WEST SUSSEX COUNTY COUNCIL CONSULTATION

TO:	Arun District Council FAO: Mr S Davis
FROM:	Highways, WSCC
DATE:	03/09/2025
LOCATION:	57 River Road, Littlehampton, BN17 5DD
SUBJECT:	LU/141/25/PL Partial demolition of number 57 River Road, change of use & re-development to provide a flatted development comprising 9 No apartments with private amenity space, parking & cycle storage, including the partial demolition of the adjacent boundary wall to provide a new pedestrian access & the creation of a floating pontoon with resident morning spaces (resubmission following LU/251/21/PL). This application affects the character & appearance of the Littlehampton River Road Conservation Area & is in CIL Zone 4 (Zero Rated) as flats.
DATE OF SITE VISIT:	N/A
RECOMMENDATION:	More Information
S106 CONTRIBUTION TOTAL:	N/A

Figure 3.7 Proposals - Ground Floor

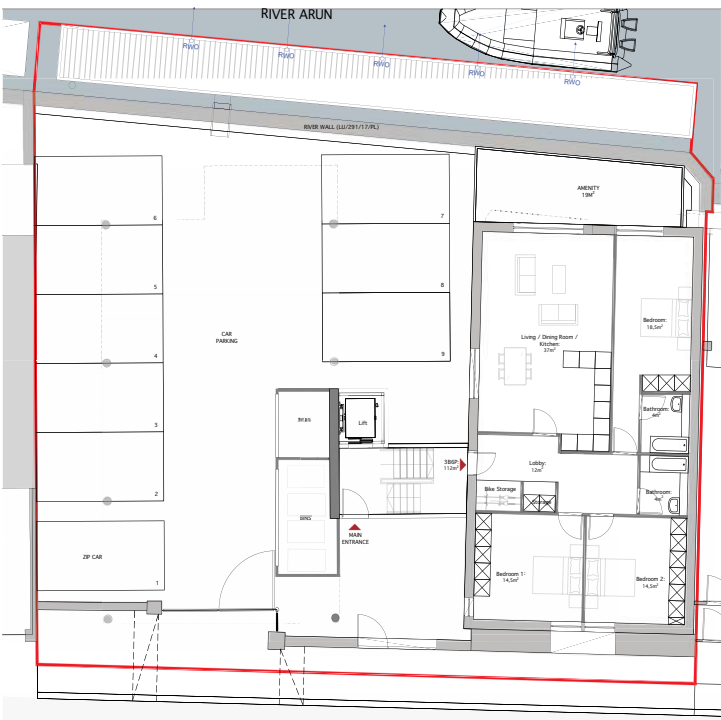
Parking and Turning: The plans demonstrate off-street parking provision for nine cars. Manual for Streets 2 11.1.9 states that parking bays require space of at least 6m in front for a car to manoeuvre in and out of the bay at 90°. Whilst this appears achievable for bays 4-9, there does not appear to be sufficient space for bays 1-3, which may make manoeuvring in and out of these bays difficult. Is there scope within the site to ensure all proposed parking bays have suitable manoeuvring space? Alternatively, can the applicant demonstrate that access and turning is achievable for all parking bays?
